From: Kevin Padilla <kpadilla@juttlarchs.com>
Sent: 13 January 2023 16:08
To: Emilie Bateman
Subject: Re: 4 NORTH DRIVE 14554/APP/2022/3488
Attachments: Side Dormer Calculation.jpg

Subject: RE: 4 NORTH DRIVE 14554/APP/2022/3488

PROPOSED FLOOR PLANS & ELEVATIONS

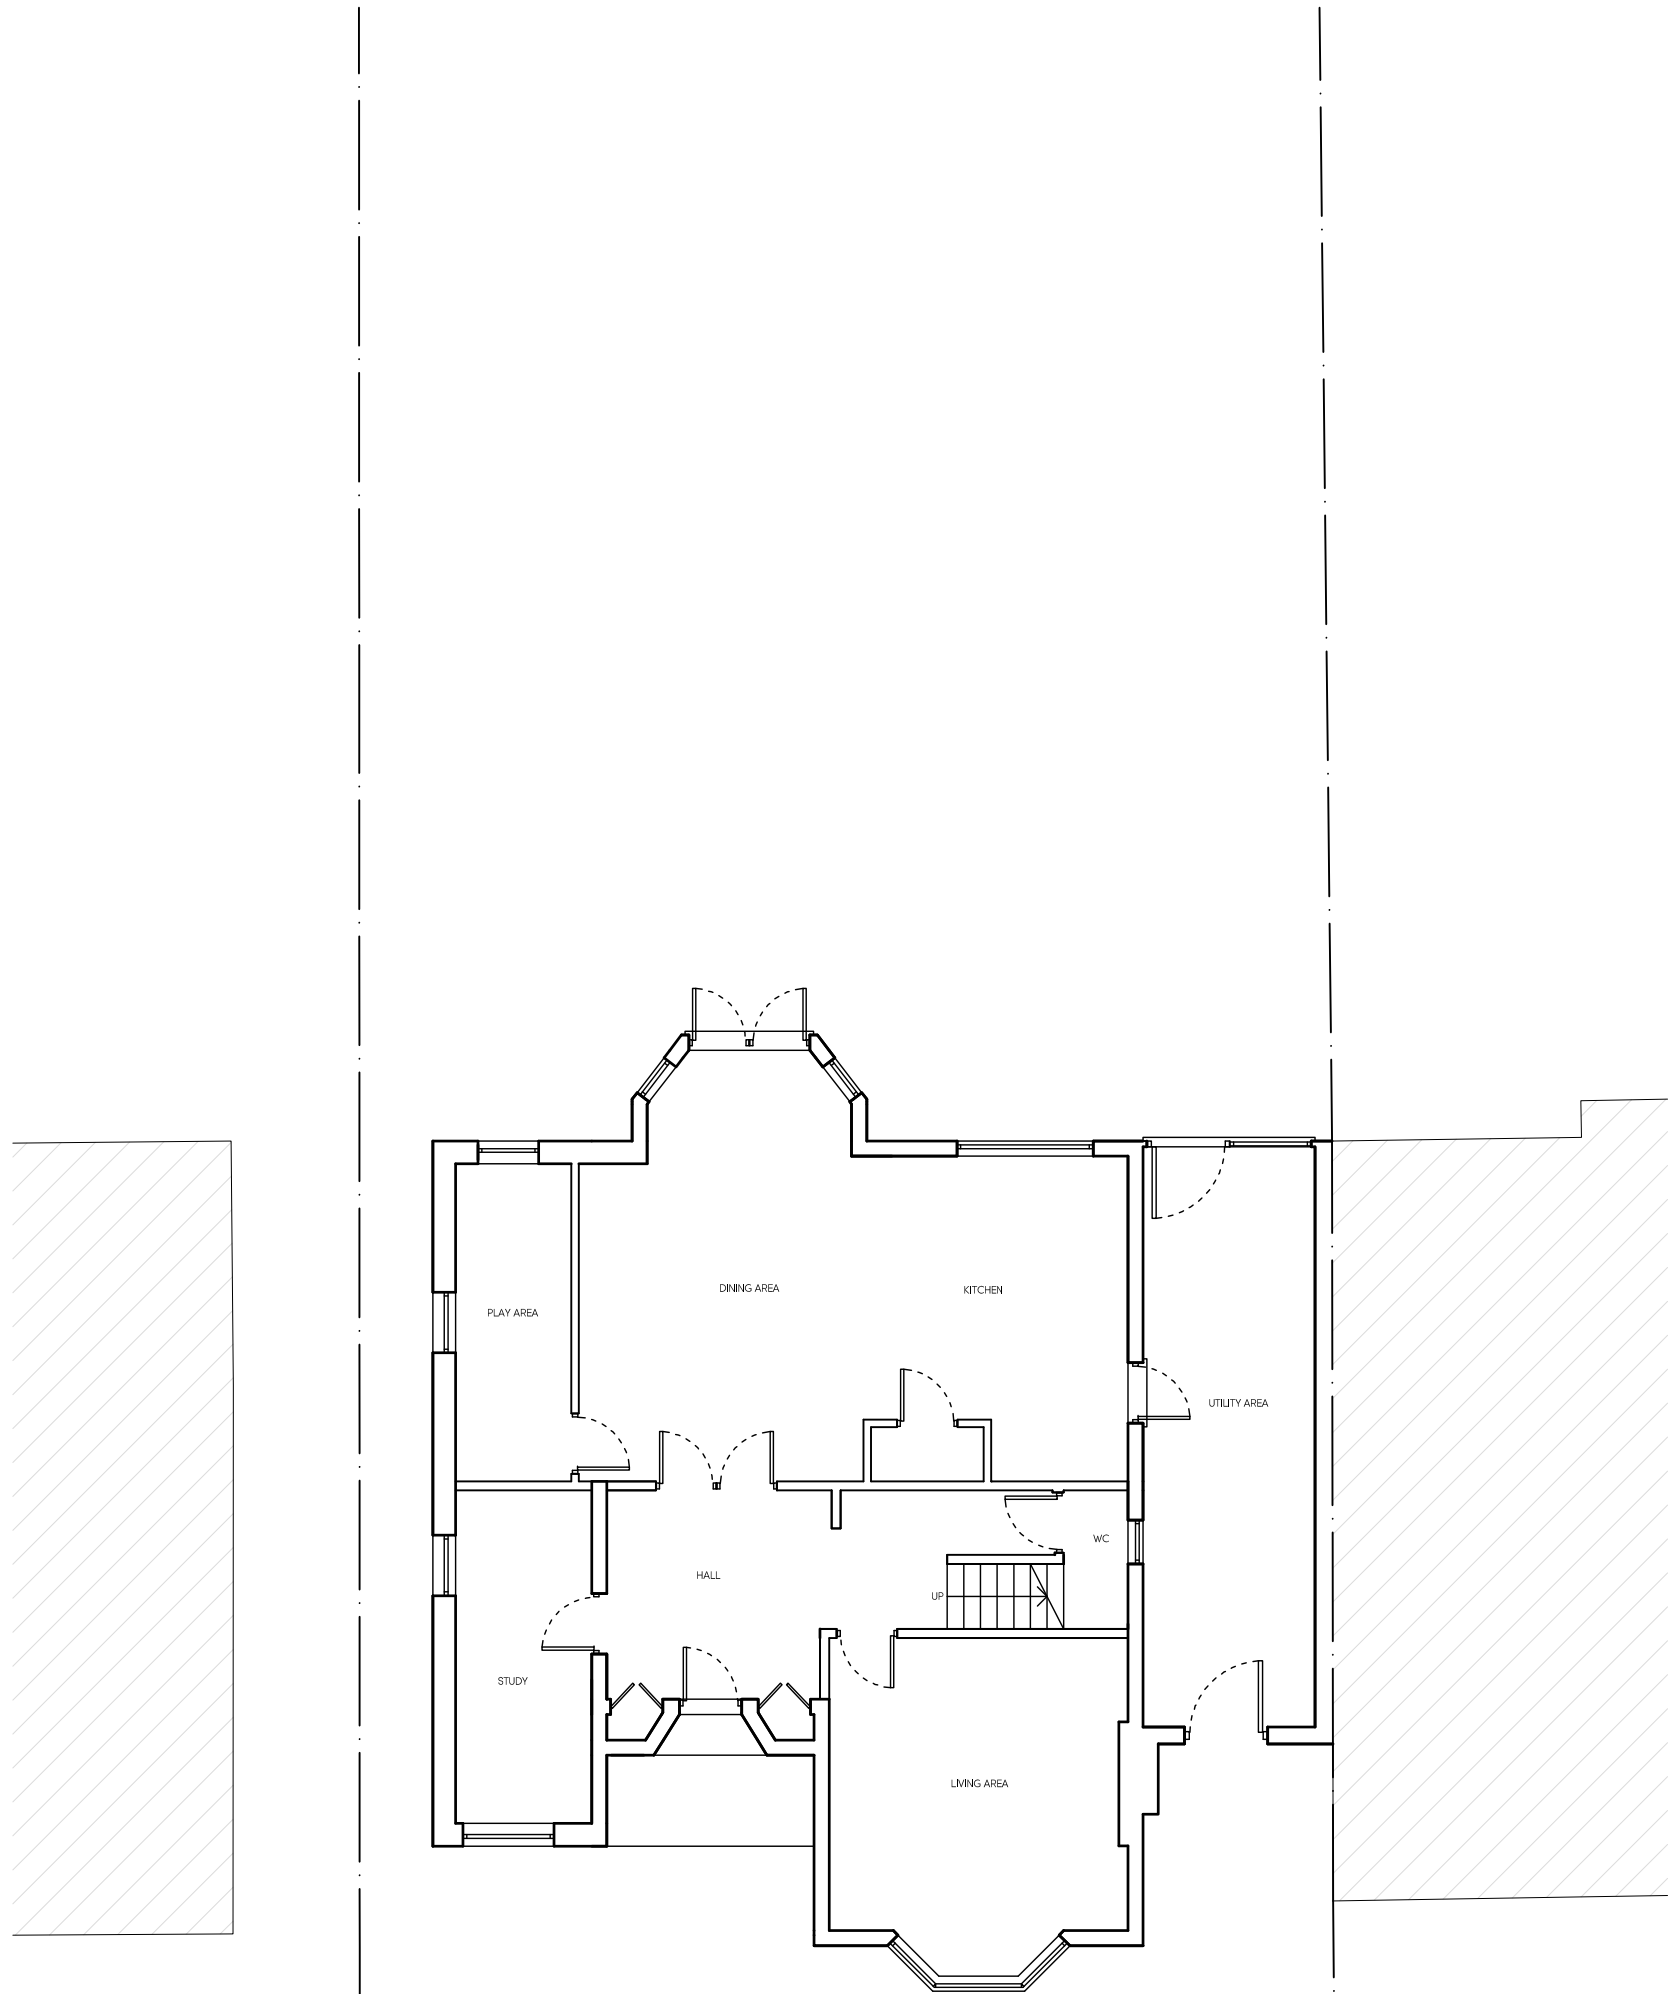
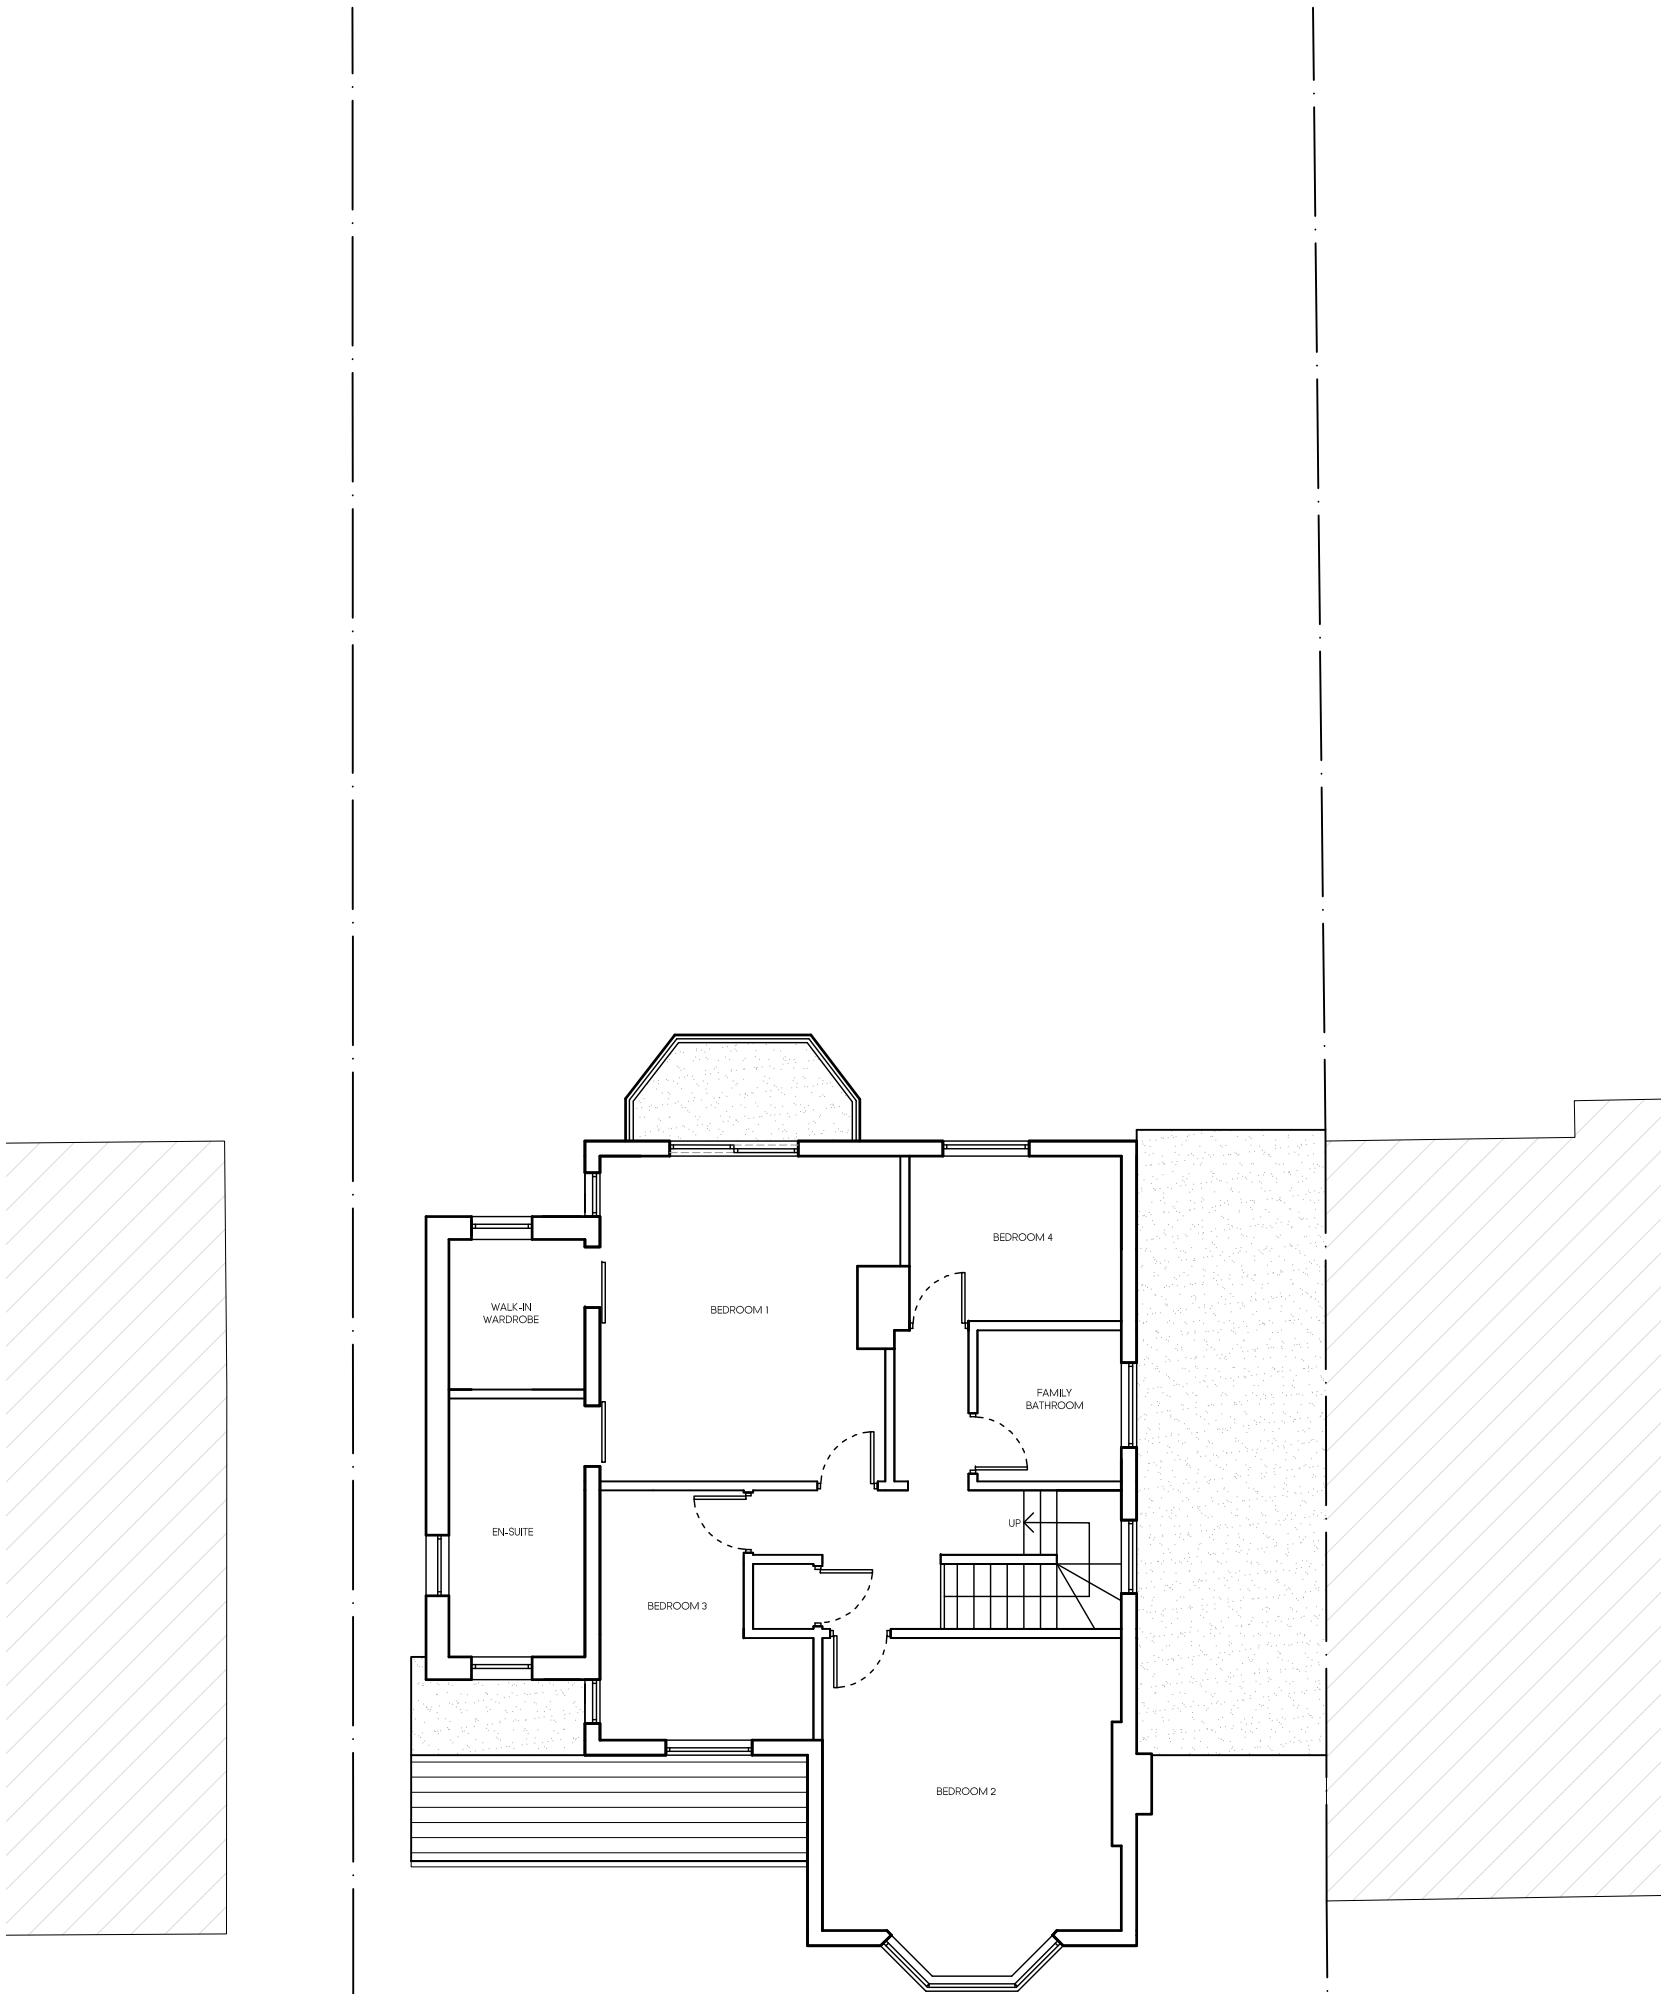
Thank you for your email – should there be a side dormer where I've highlighted yellow?

I have also amended the front elevation as the dormer was not on the right side.

PROPOSED LOFT FLOOR PLAN, ROOF PLAN & ELEVATIONS

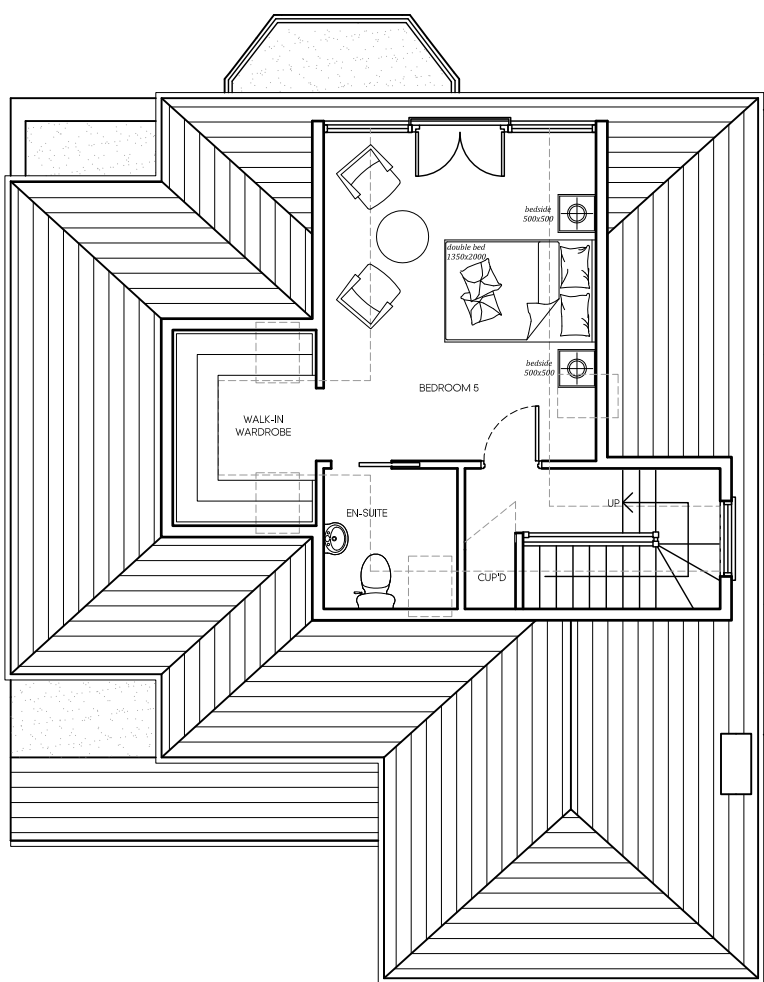
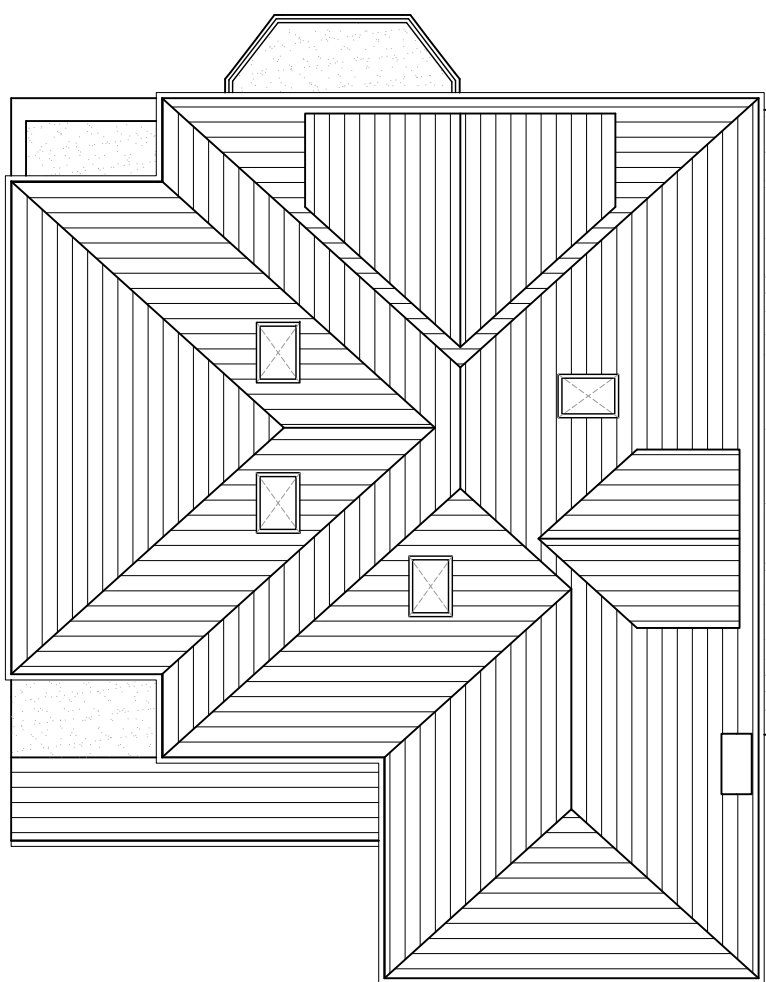
Great – thank you for your prompt response. Please can you also add the side dormer onto the rear elevation plans?

Apologies for the confusion, please find the attached revised drawings.

Please find the attached revised drawing as per you request.

PROPOSED LOFT FLOOR PLAN, ROOF PLAN & ELEVATIONS

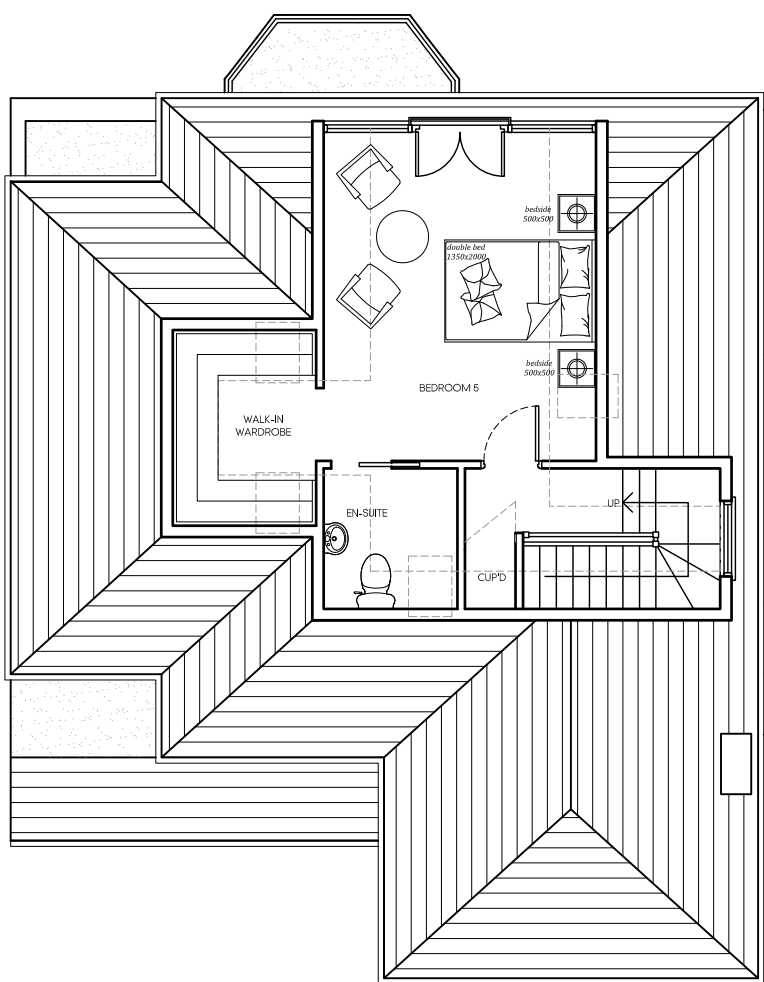
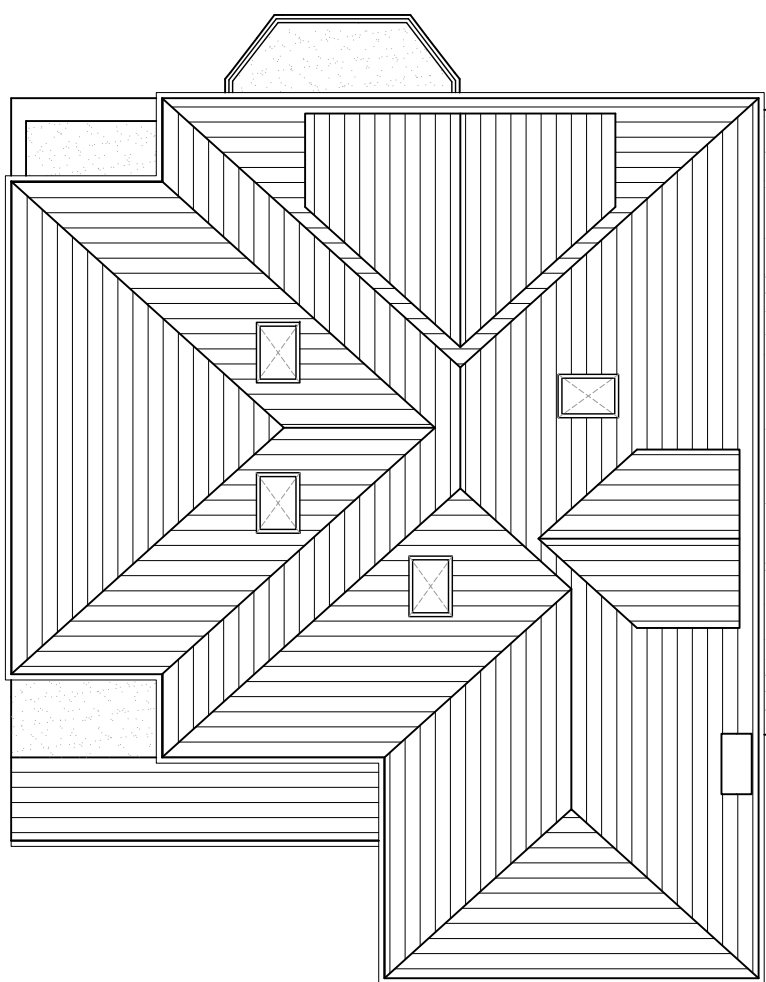
Upon review the 'hip to gable to the rear' would be considered as a dormer.

As a result, we are coming to a different figure as we calculating the addition as a dormer with a triangular roof. It would be really help to have each shape broken down in each calculation so we can understand where we are not in agreement.

Please triple check the calculation as the scale may need to be reduced.
